CITY OF PORTLAND, MAINE

PLANNING BOARD

April 3, 2017

Project Name: **502 Deering Center: 6-unit residential development plus 1 commercial space**
Project ID: #2016-290 (Subdivision & Site Plan)
Address: 502 Stevens Avenue CBL: 135-E-9
Applicant: Denis Lachman
Planner: Matthew Grooms

8 SIDEWALK RAMPS
NOT TO SCALE

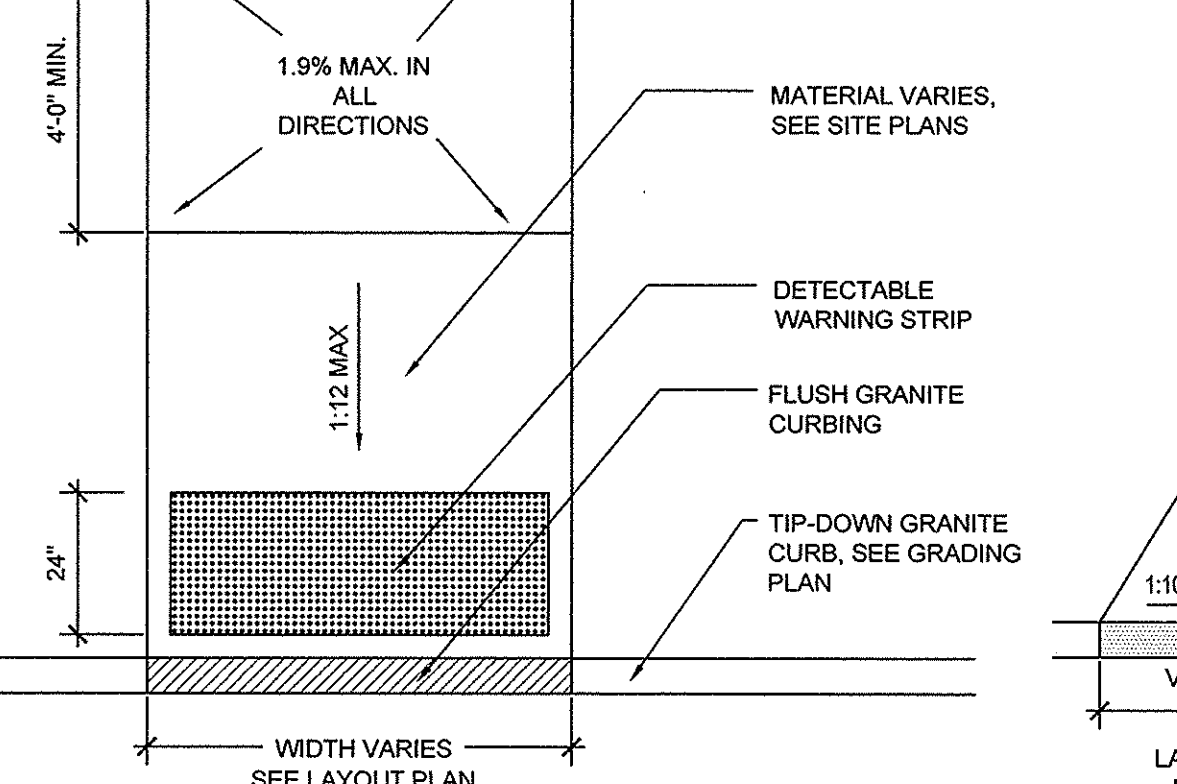
4. The sidewalk ramp design detail at the southeast corner of Hartley Street shall be revised to be in compliance with City Standards (less than 2 percent slope). The revised detail shall be submitted for review and approval by the Planning Authority.
